Your Ref: OWPC24981
Our Ref: FP/220/19/HH
Please ask for:
Amber Willard

Single storey extensions to front and rear elevations, all existing windows/doors/balcony to be replaced and new slate roof
14 Sea Drive Felpham

Thank you for your internet comments made on 22nd November 2019 which has been recorded as **'an objection'** with the comments as follows:

Front Elevation - Facing South

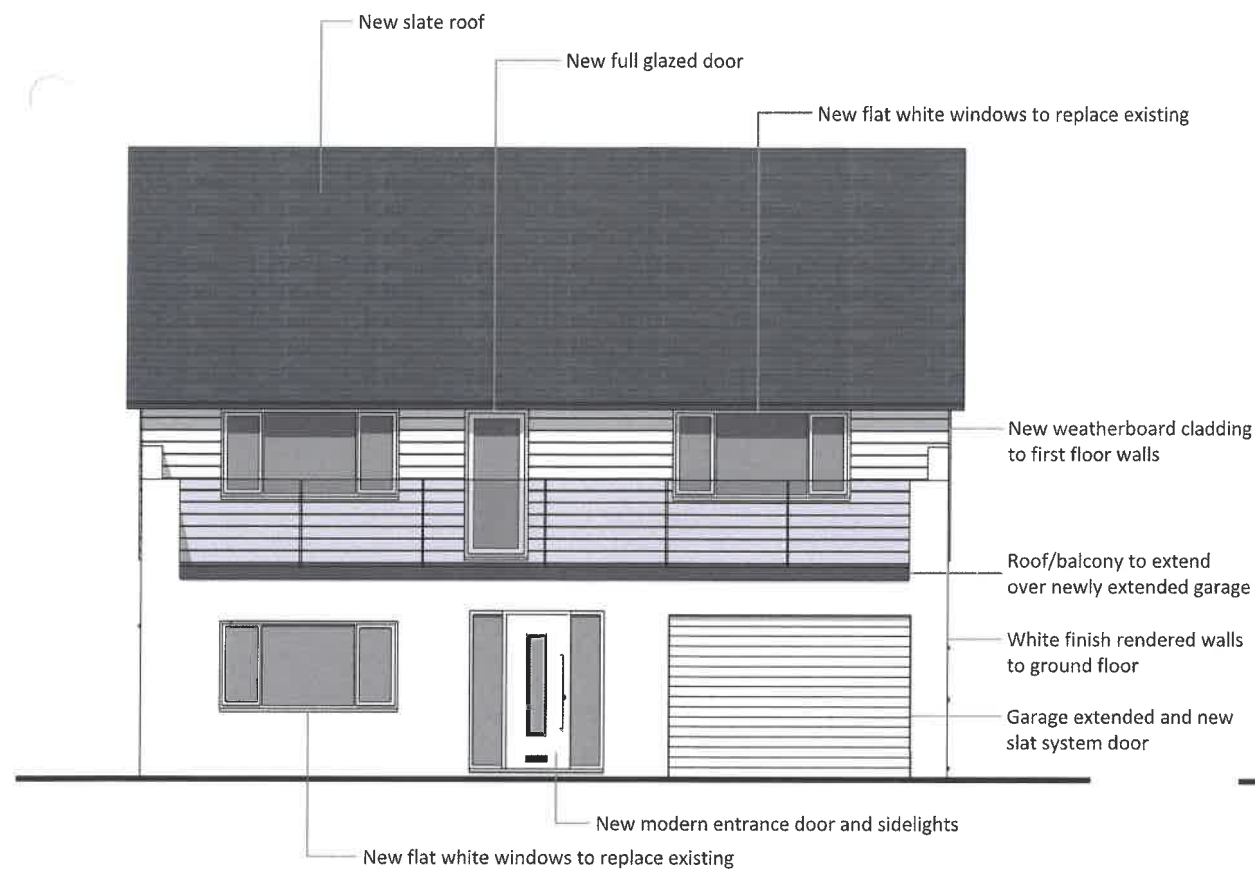
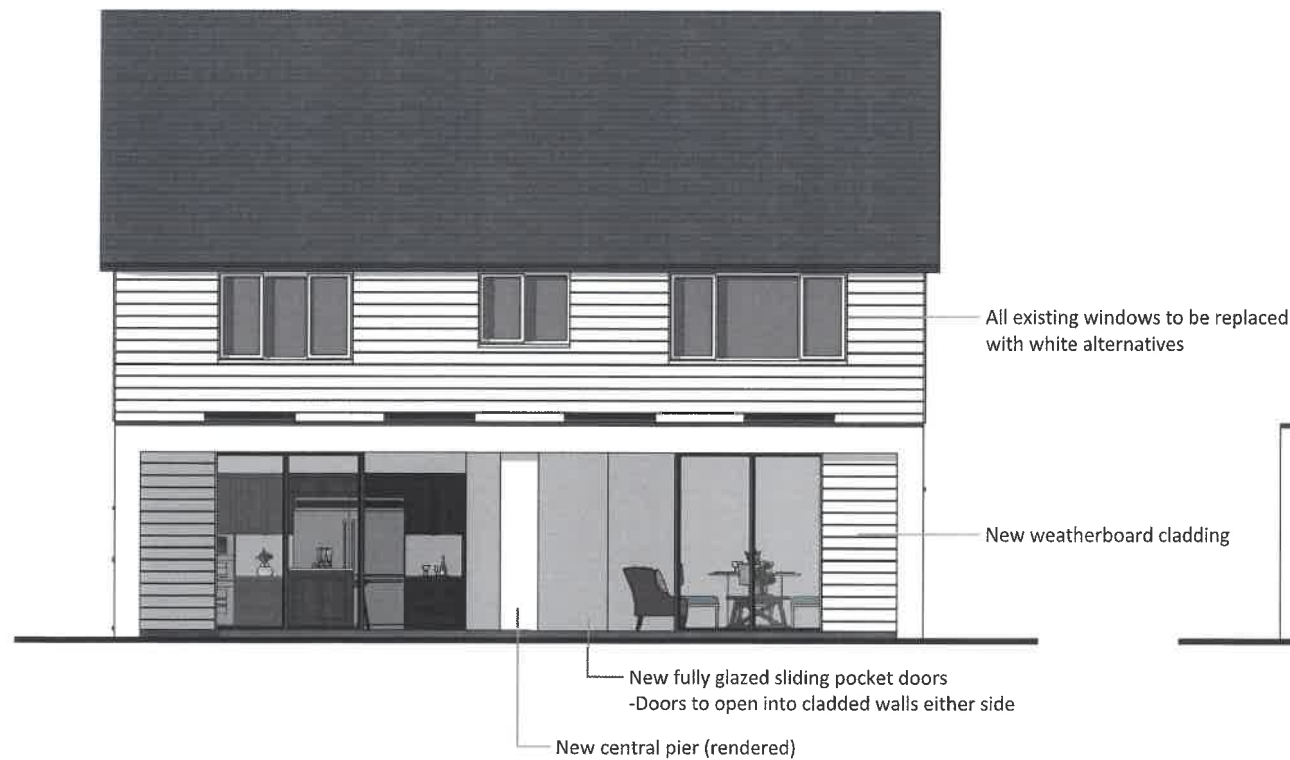
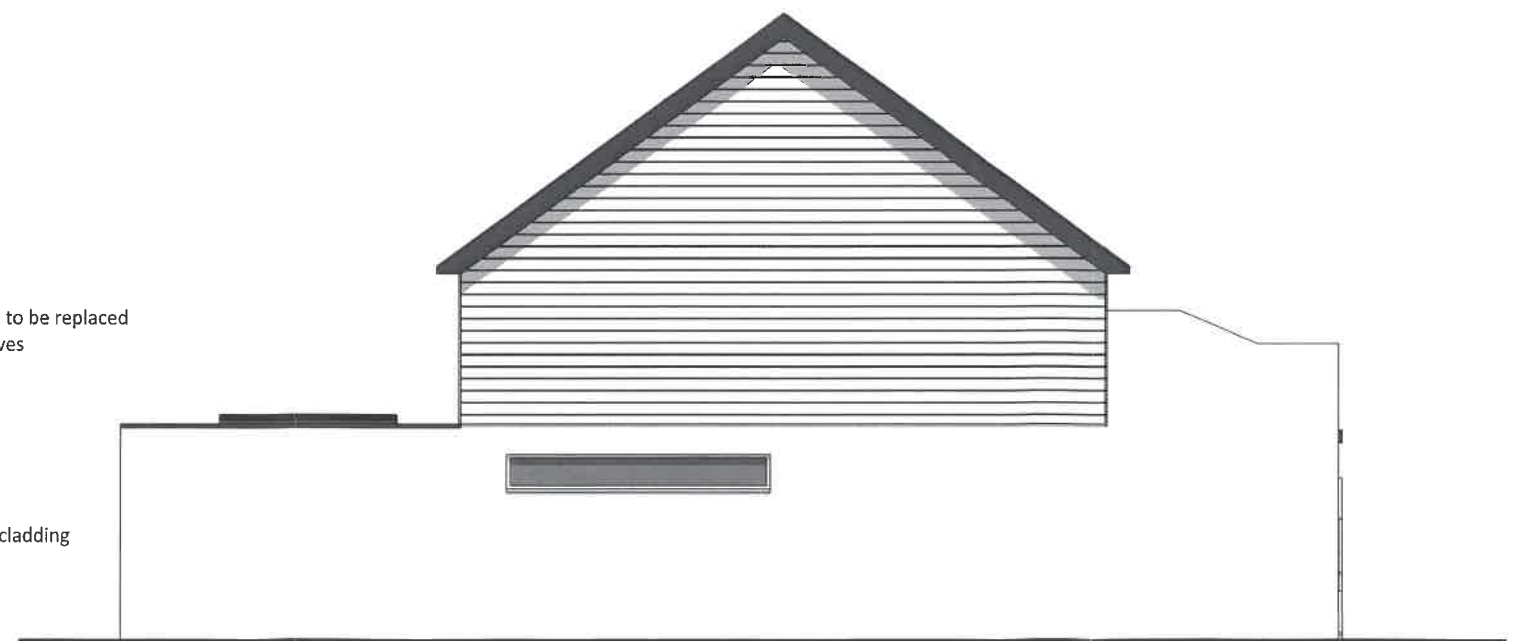
Objection - not clear from application that balconies have obscured glass to 1.5 metre height.
